RZ-1

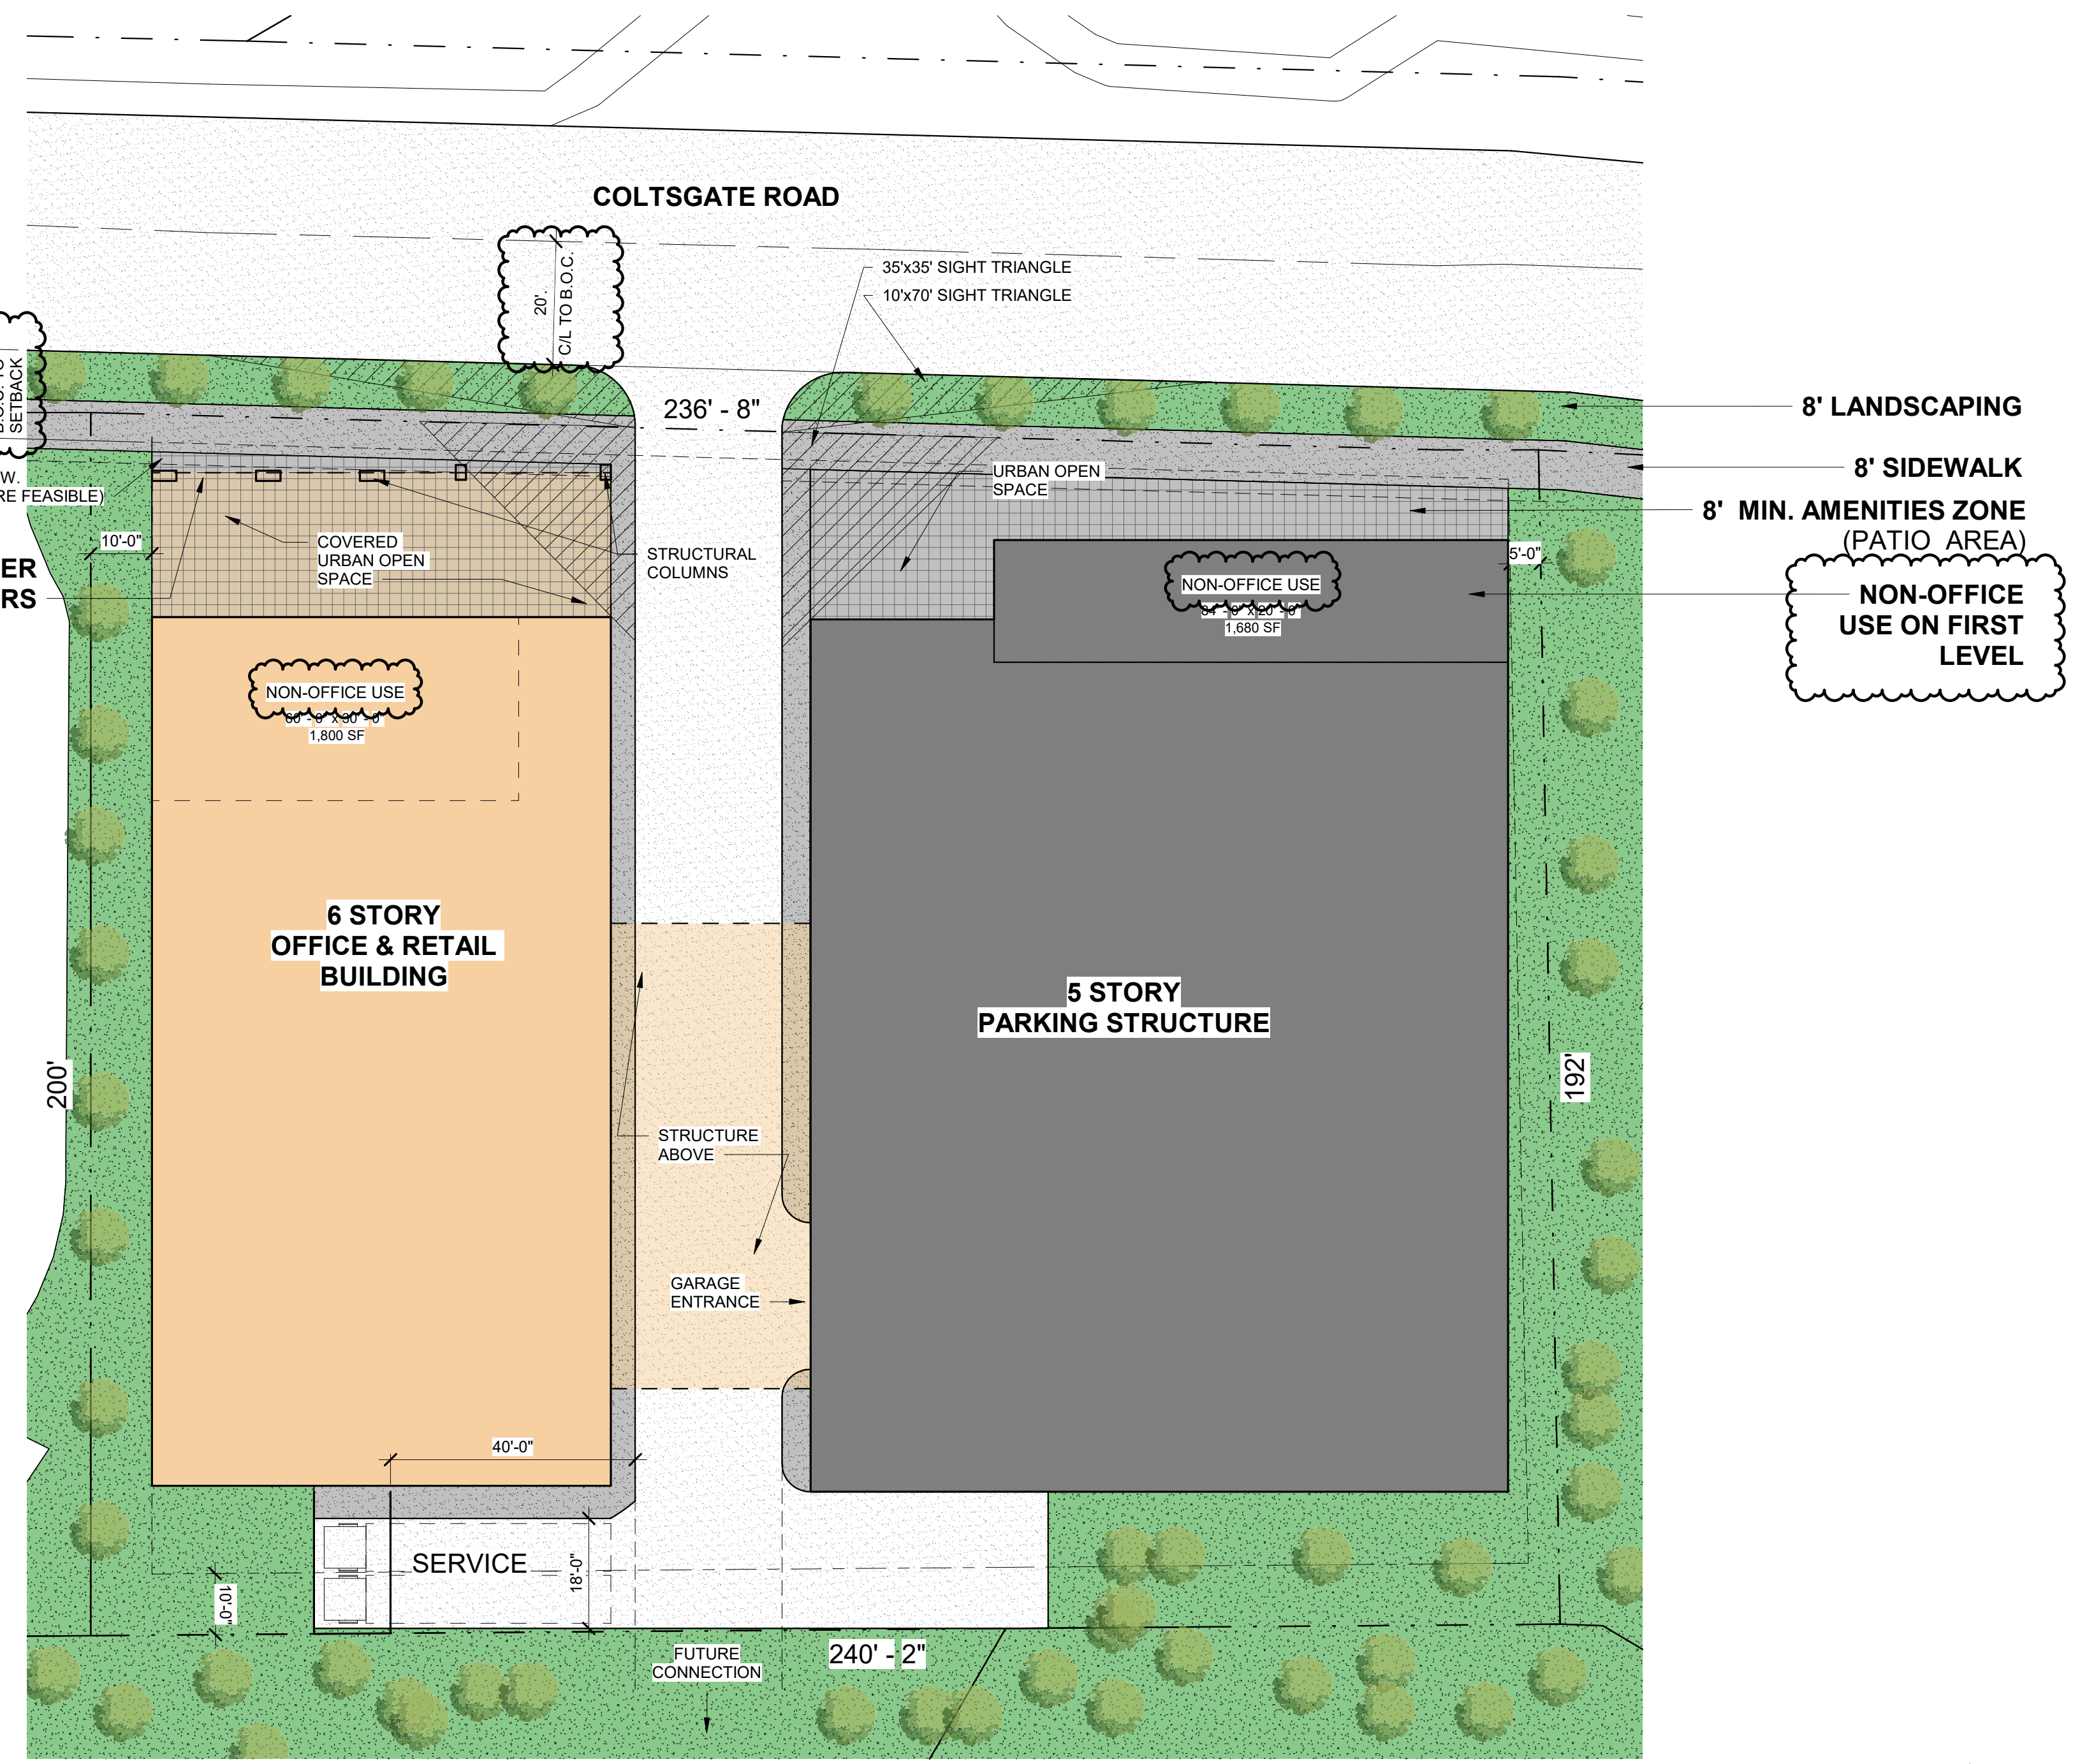
Acela Number	
2019-170	1- Fire hydrant shall be located within 750' to the most remote point of building as truck travel for all buildings. 2- For non-sprinkled buildings. Fire department must be able to reach all
2019-171	No Comments. Rezoning request.
2019-172	No Comments. Rezoning request.
2019-173	No Comments. Rezoning request.
2019-174	1- Fire hydrant shall be located within 750' to the most remote point of building as truck travel for all buildings. 2- For non-sprinkled buildings. Fire department must be able to reach all exterior portion of building within 150' from access road. 3- For sprinkled buildings. Fire department must be able to reach all exterior portion of building within 200' from access road. 4- For buildings that is equipped with a sprinkler system. A fire department connection shall be
2019-175	1-Fire department access road shall have a min. 20' unobstructed clear width and shall be capable of supporting 80,000 lbs. 2- Fire hydrant shall be located within 750' to the most remote point of building as truck travel for all buildings. 3-Turn radius 30' inside and 42' outside. 4-For buildings that is equipped with a sprinkler system. A fire department connection shall be located within 200' of a fire hydrant for
